1911-078

RESPONSES TO REVIEW COMMENTS FOR INTAKE SCREENING

SHEET TITLE
MAIN FLOOR PLAN

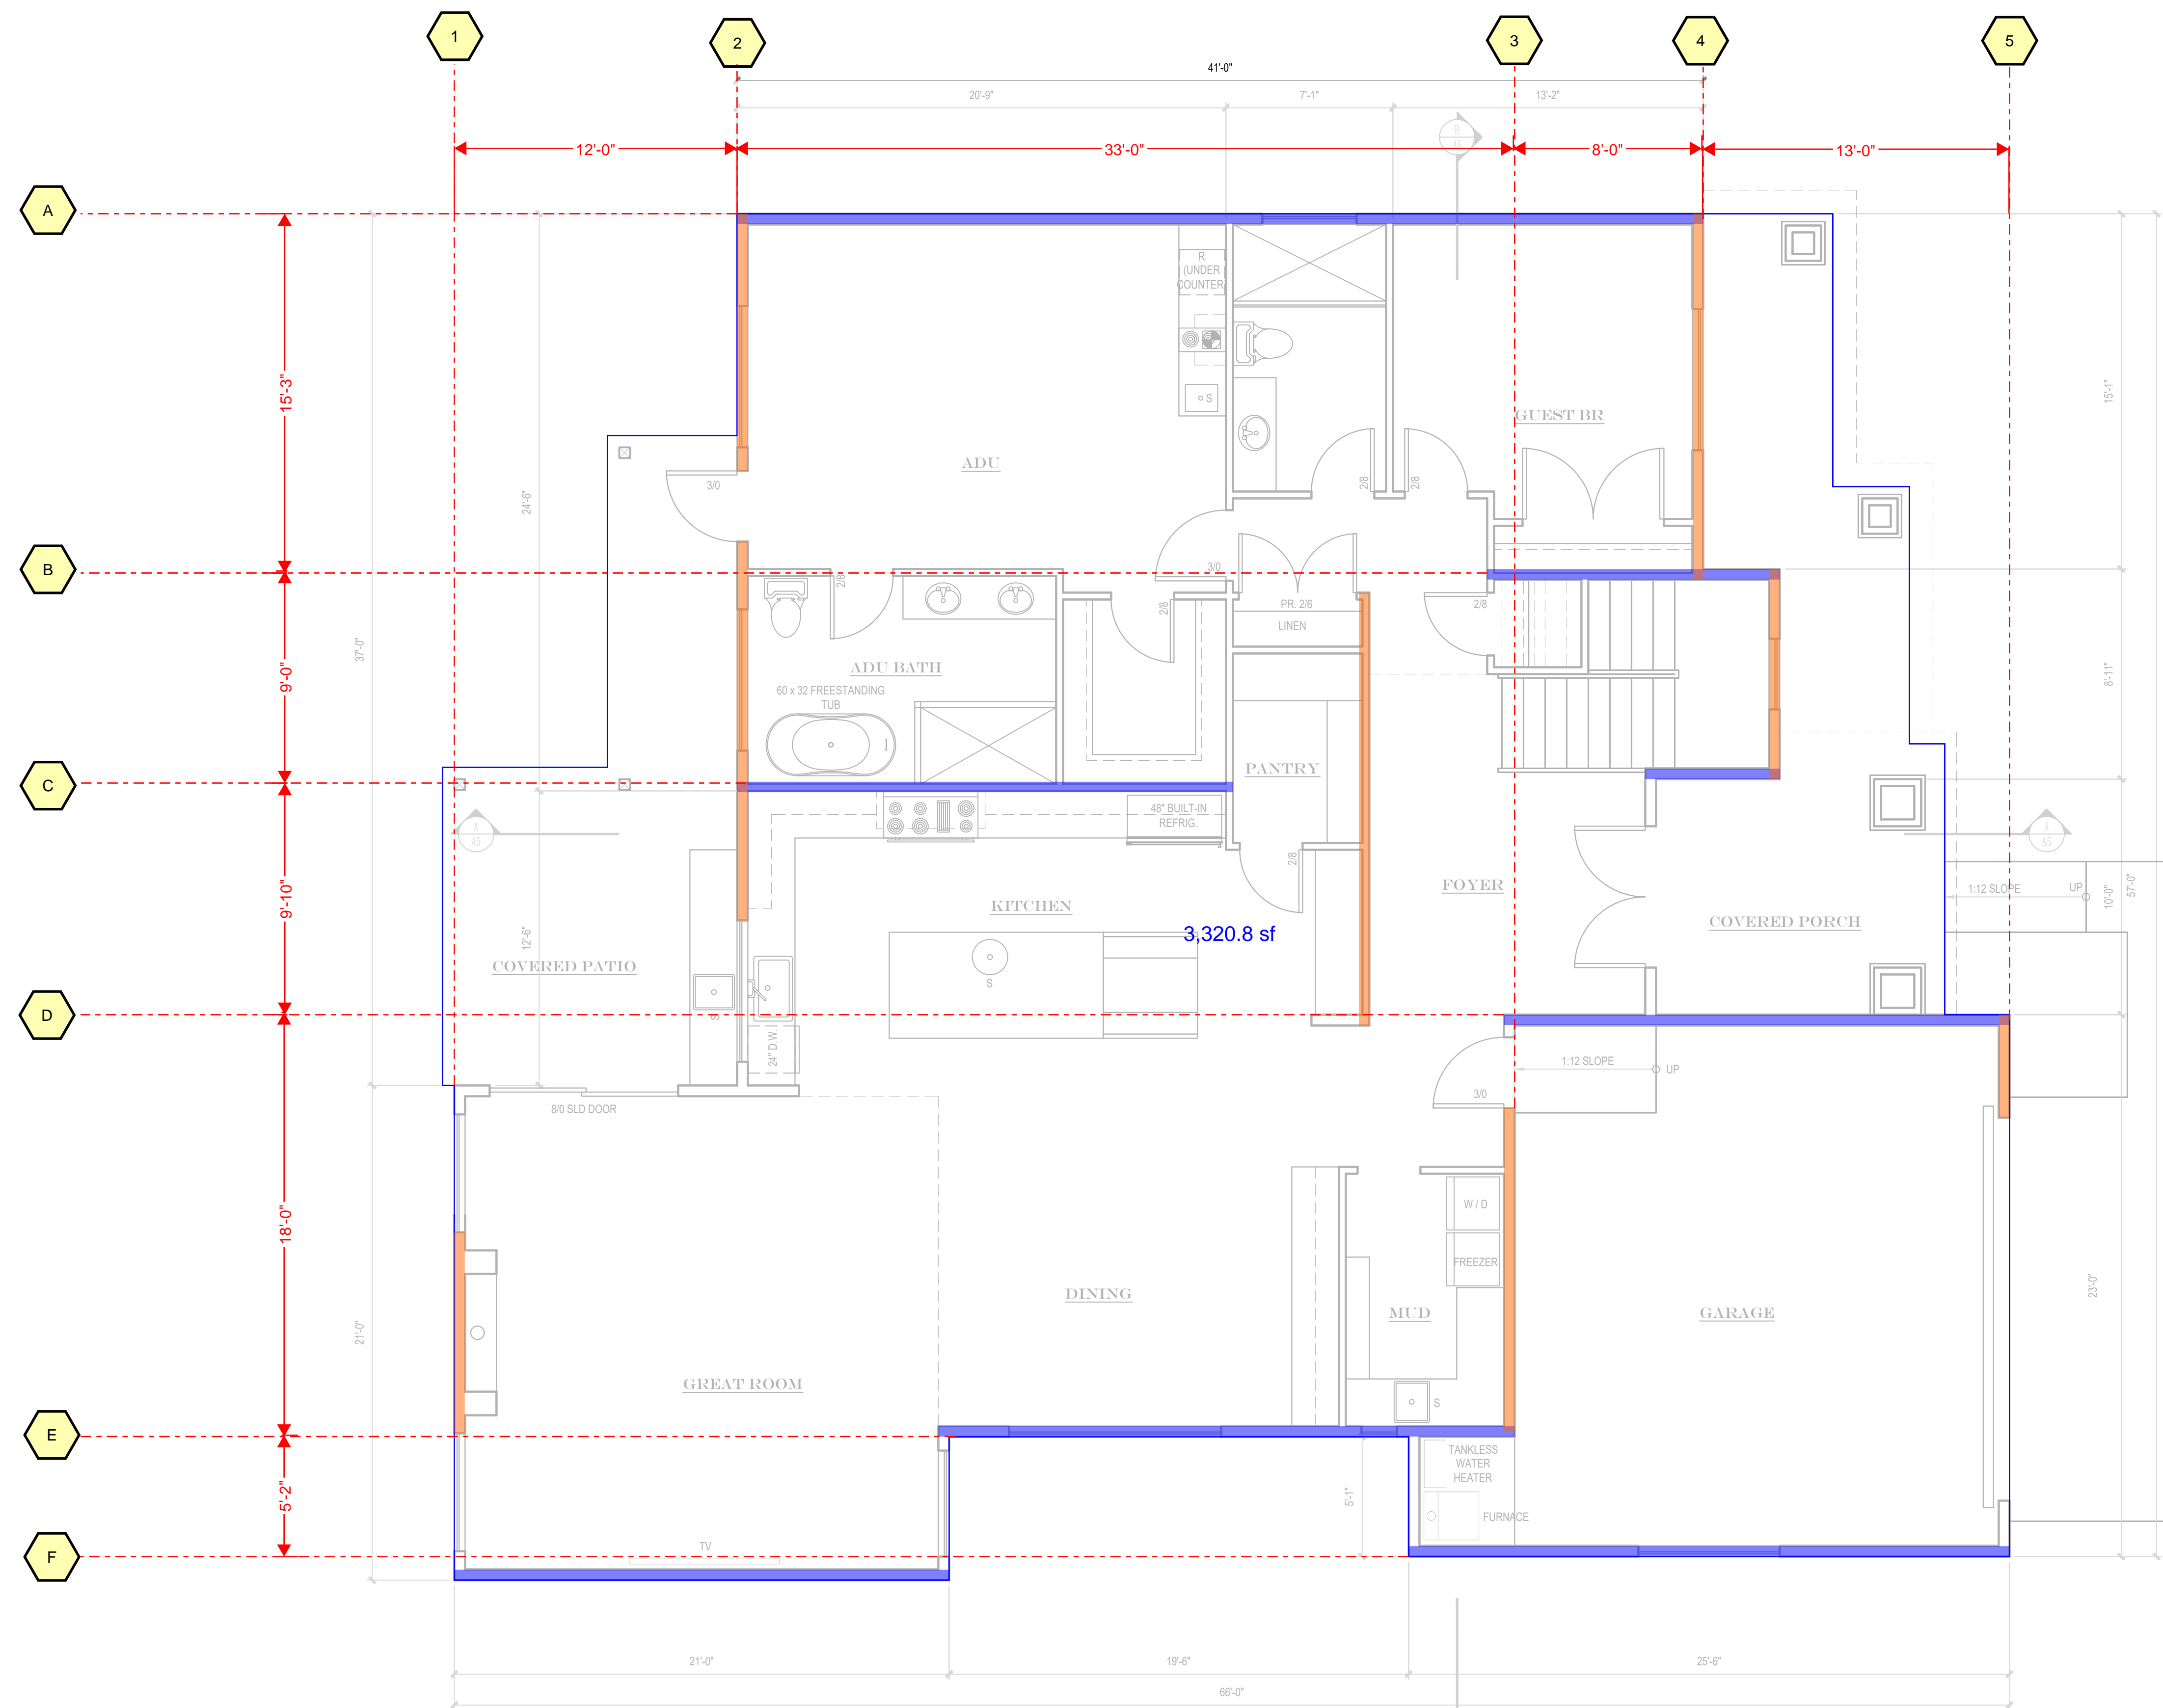
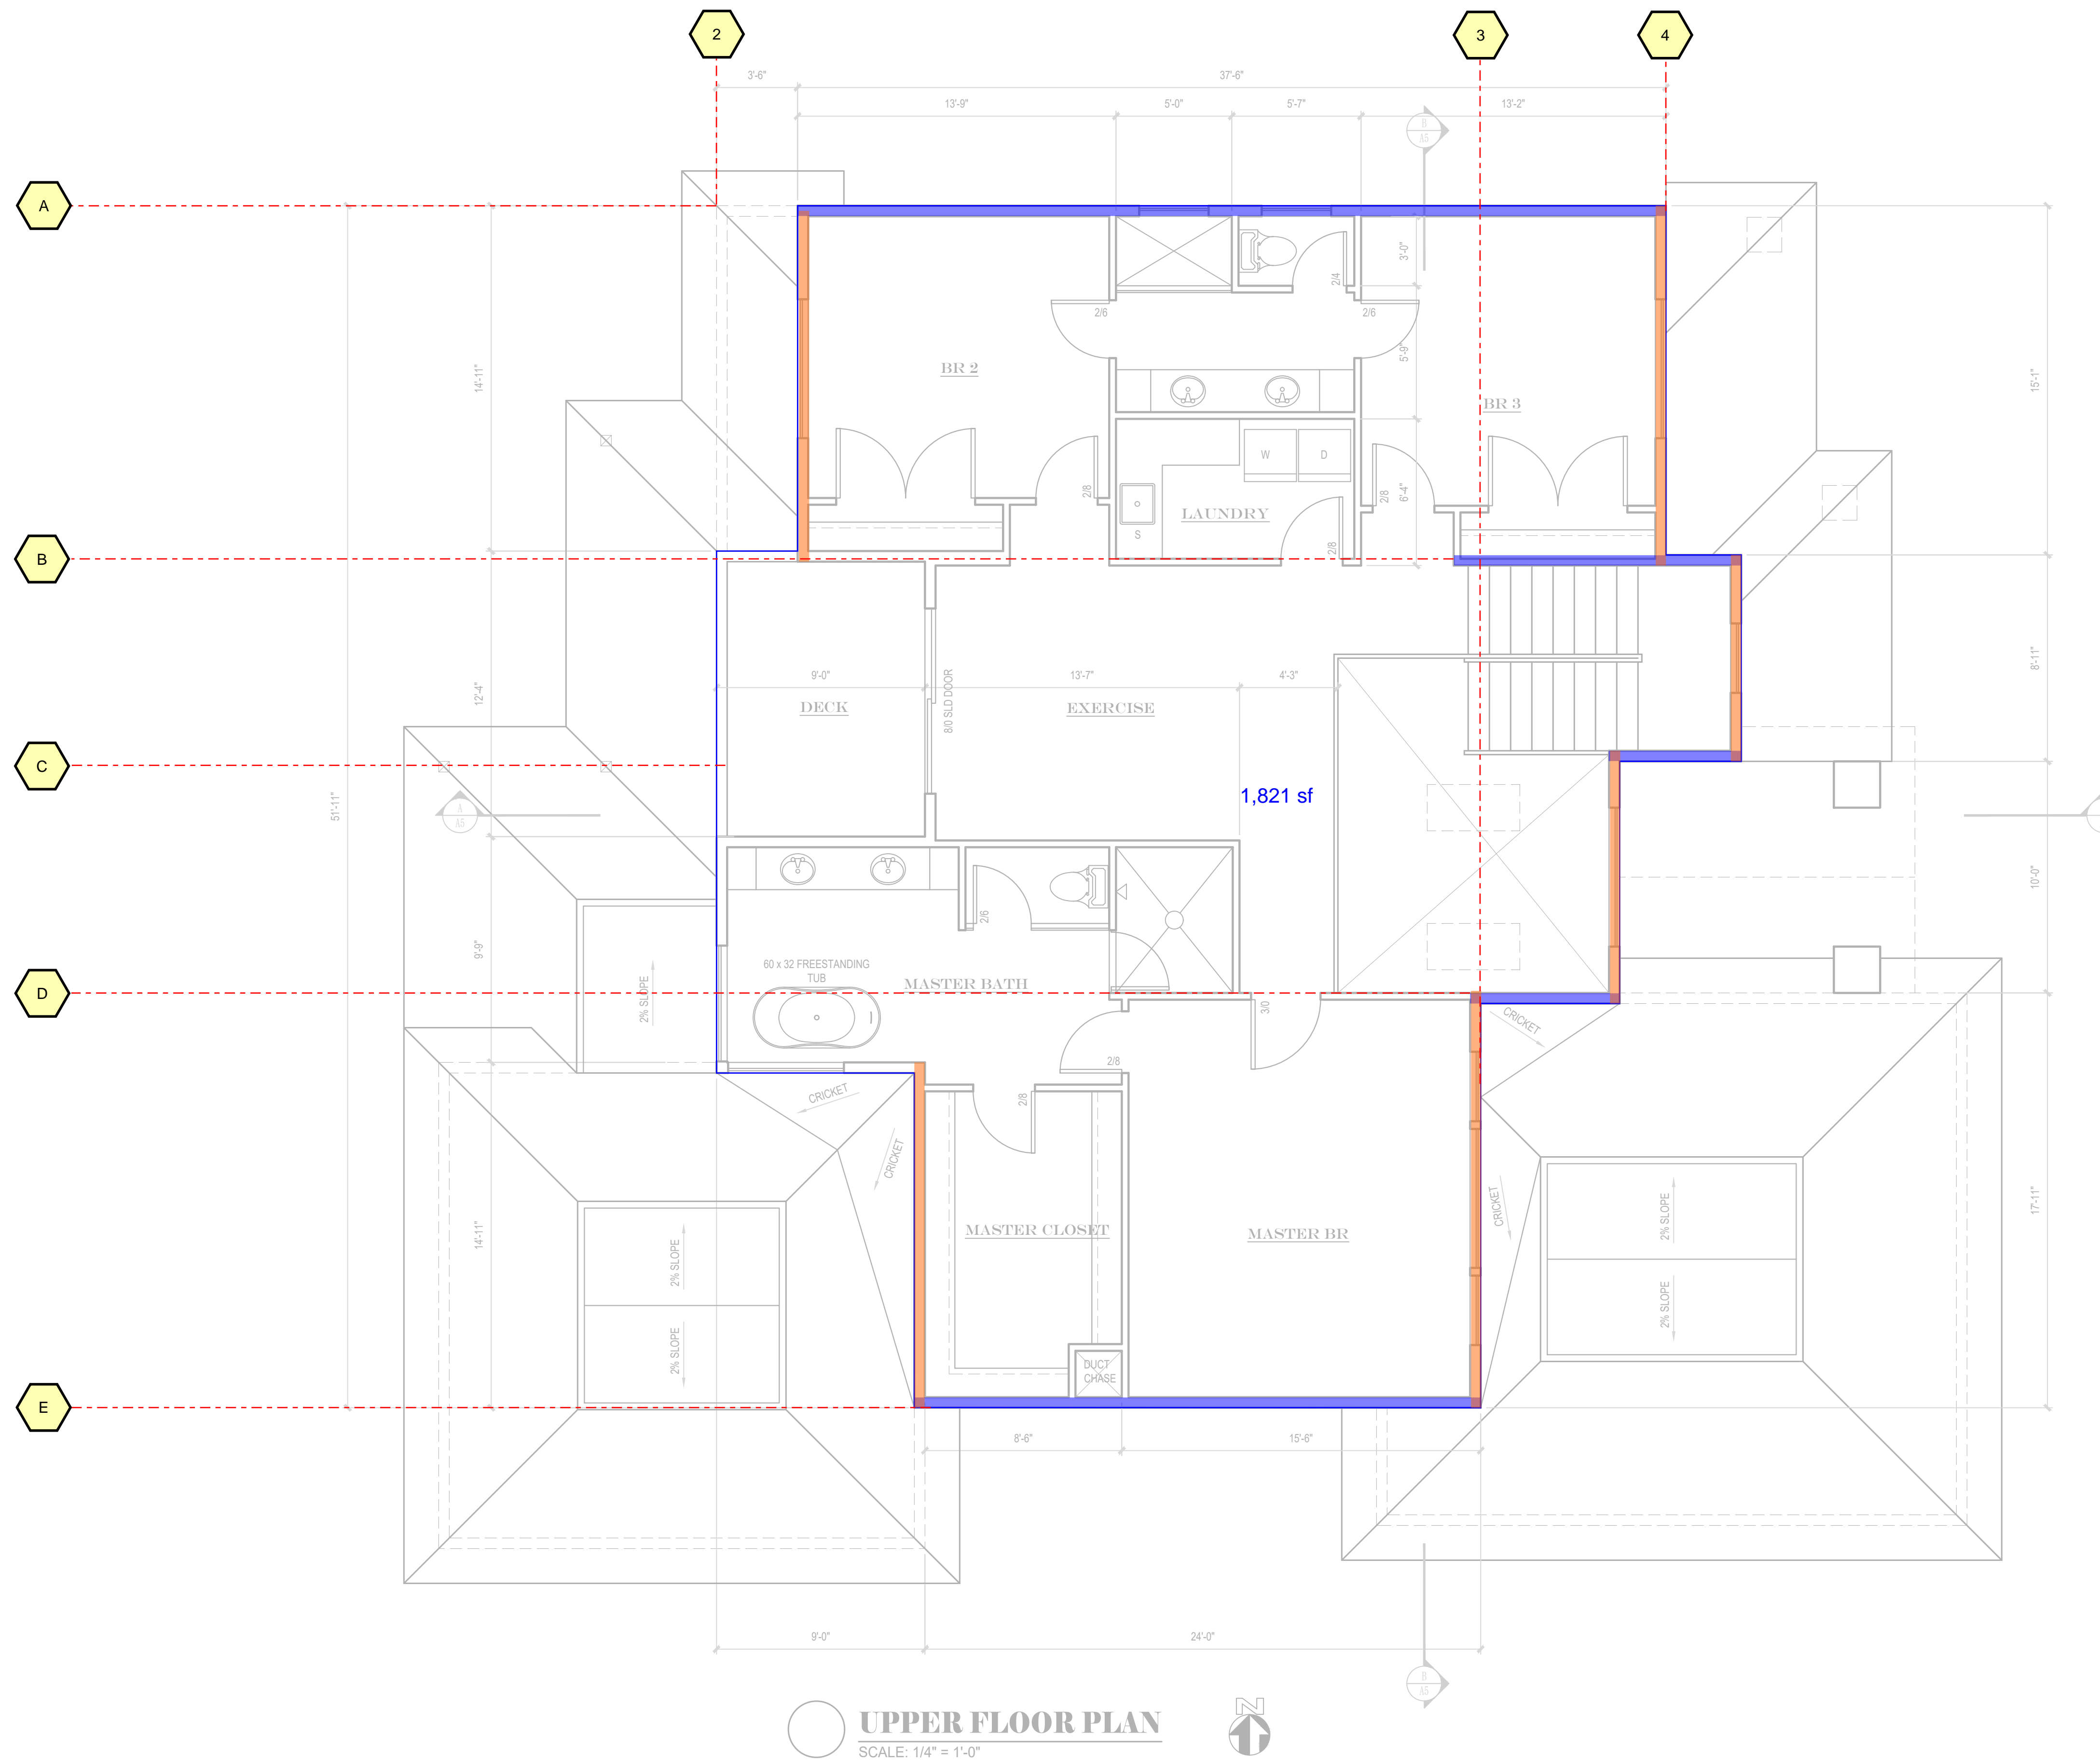
Include WSEC energy option information and any equipment requirements on construction documents
Include a complete description of Whole House Ventilation system on construction documents

Clearly note the Energy Credit options on the drawings, i.e. callout furnace, water heater, etc. on the drawings.

See corrected 2015 WSEC & IRC Ventilation Worksheet and added notes in garage at main floor plan of sheet A1.

SITE PLAN
 SCALE: 1" = 10'-0"
 N 89°03'25" W 300.00'
 N 89°03'27" W PLAT

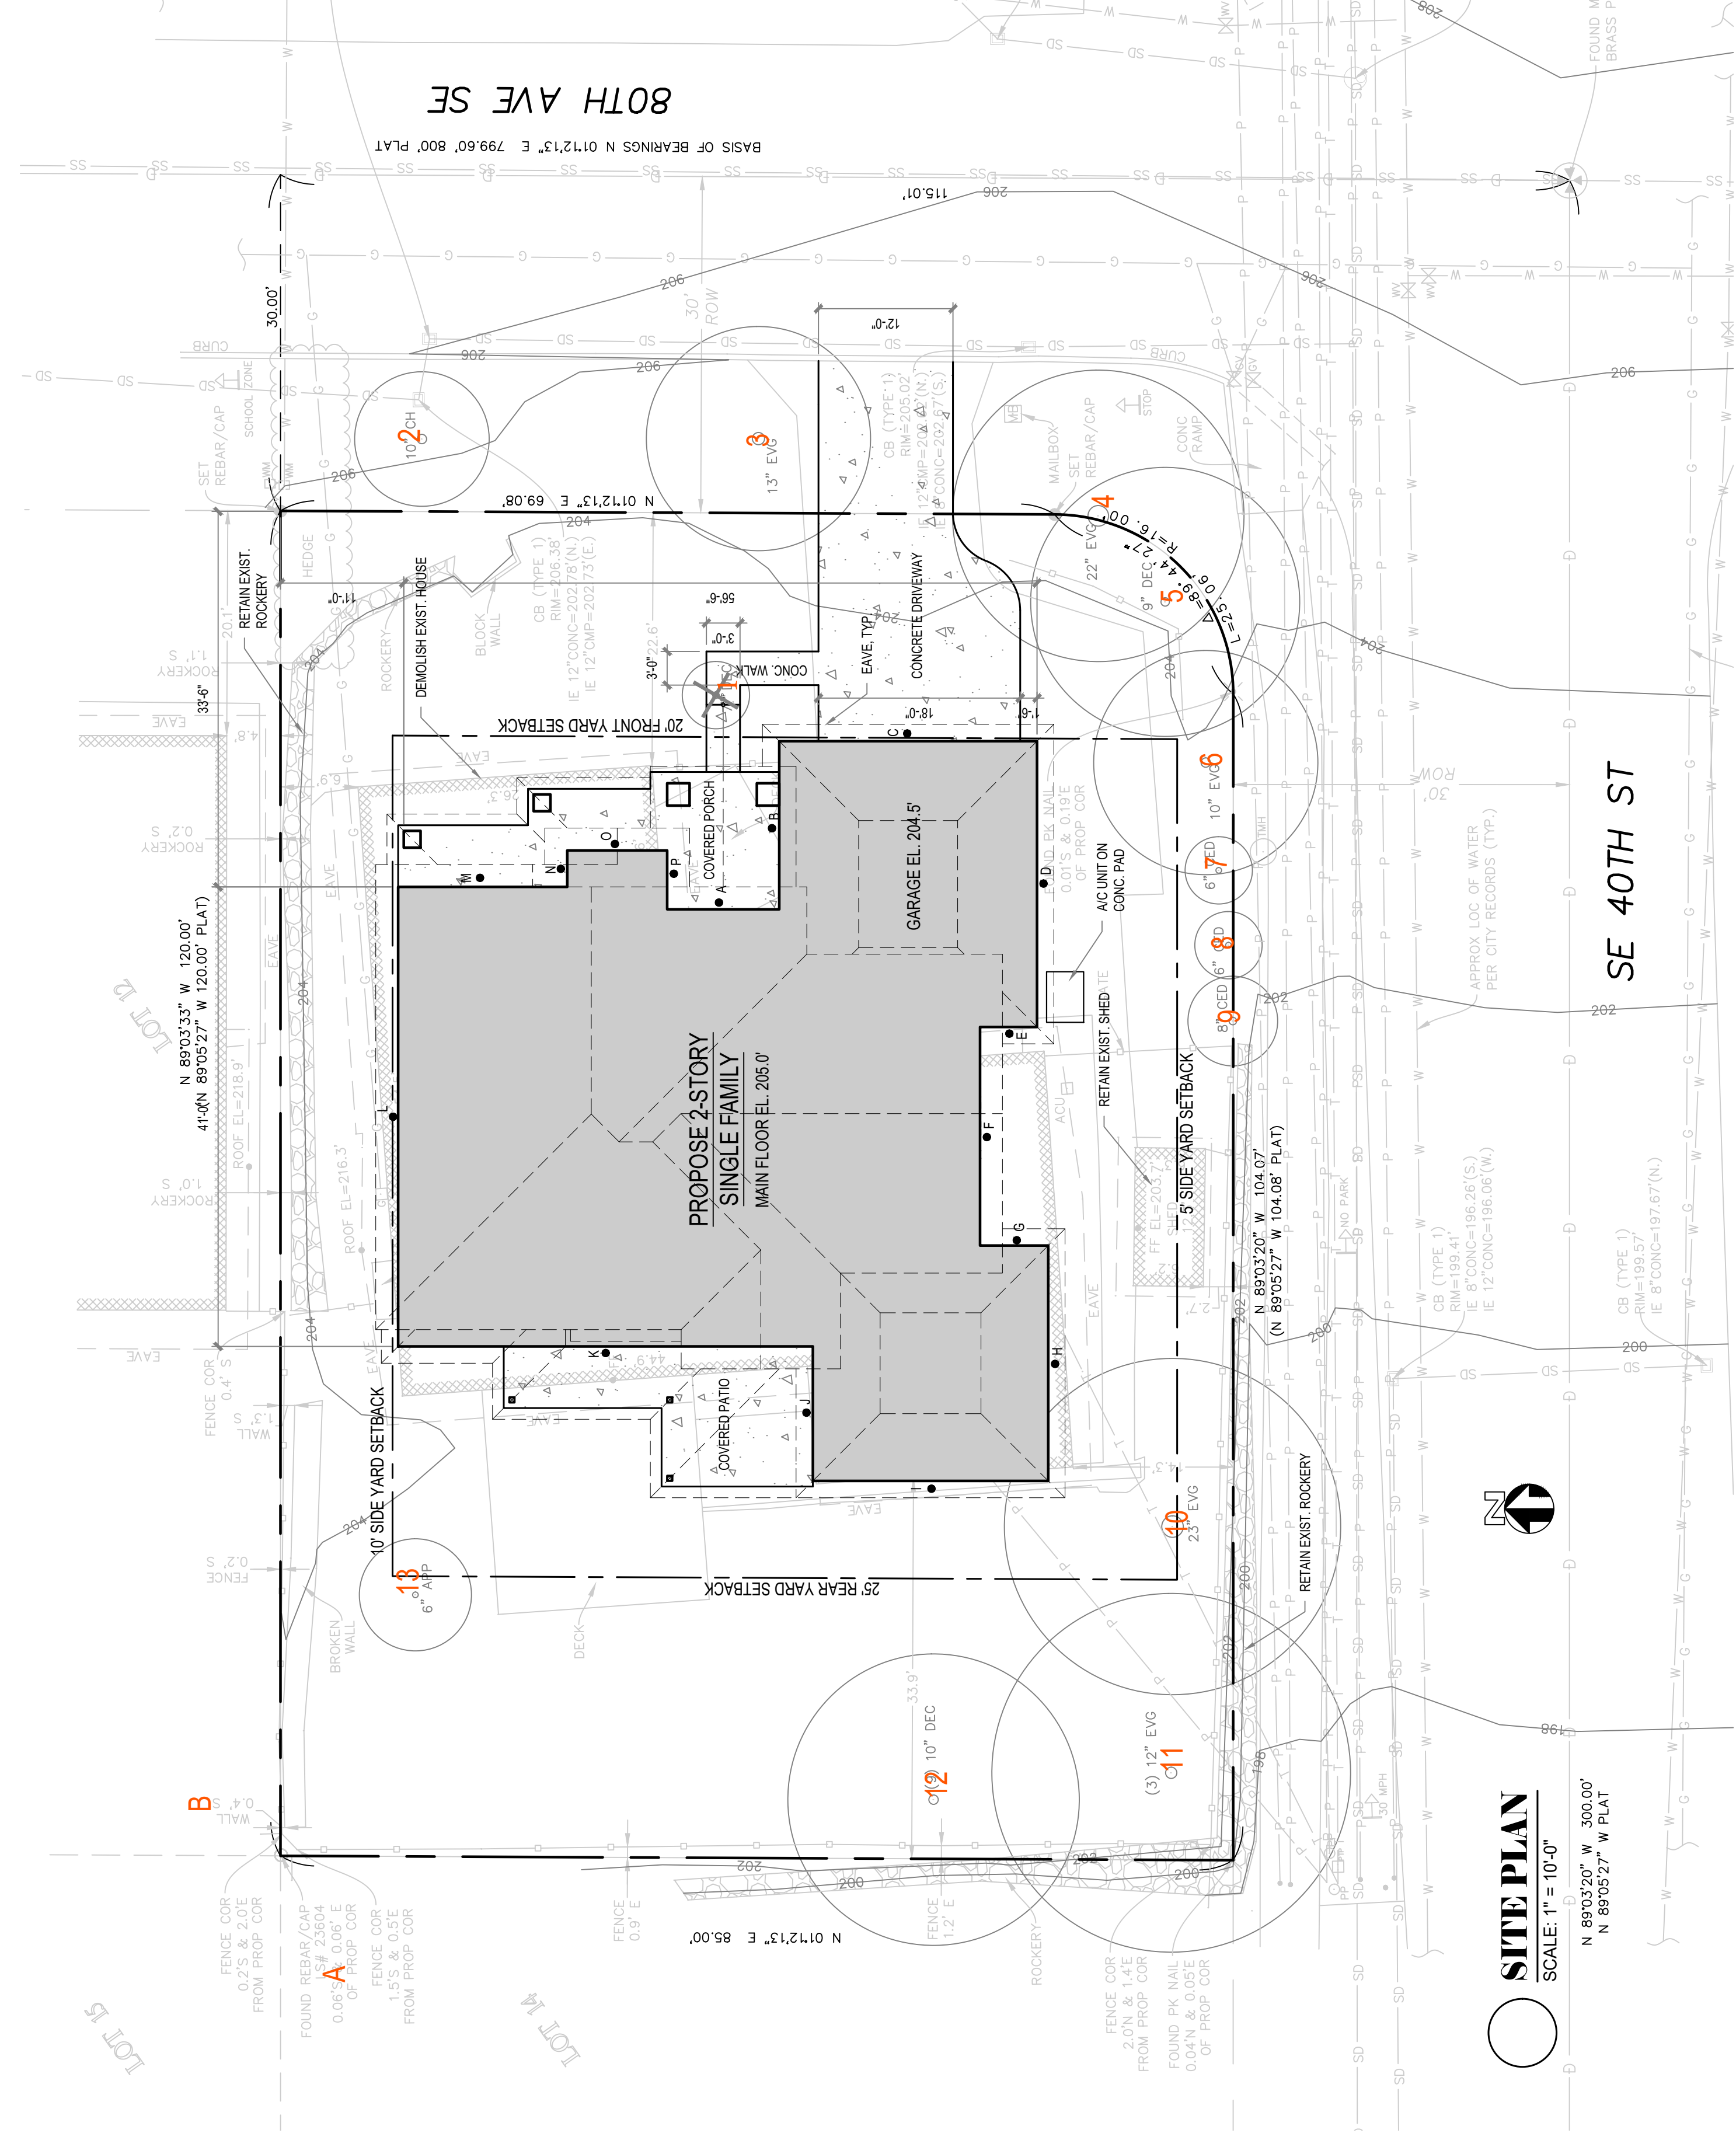
- MICC 19.02.020(C)(3)(a)(ii) states that no penetration shall be allowed into the minimum side yard setback abutting an interior lot line. The eaves of the proposed house penetrate into the minimum, 5-foot side yard setback. The eaves will need to be adjusted so they do not penetrate the minimum side yard setback.

The proposed house is shifted to avoid eave encroaching to setback.
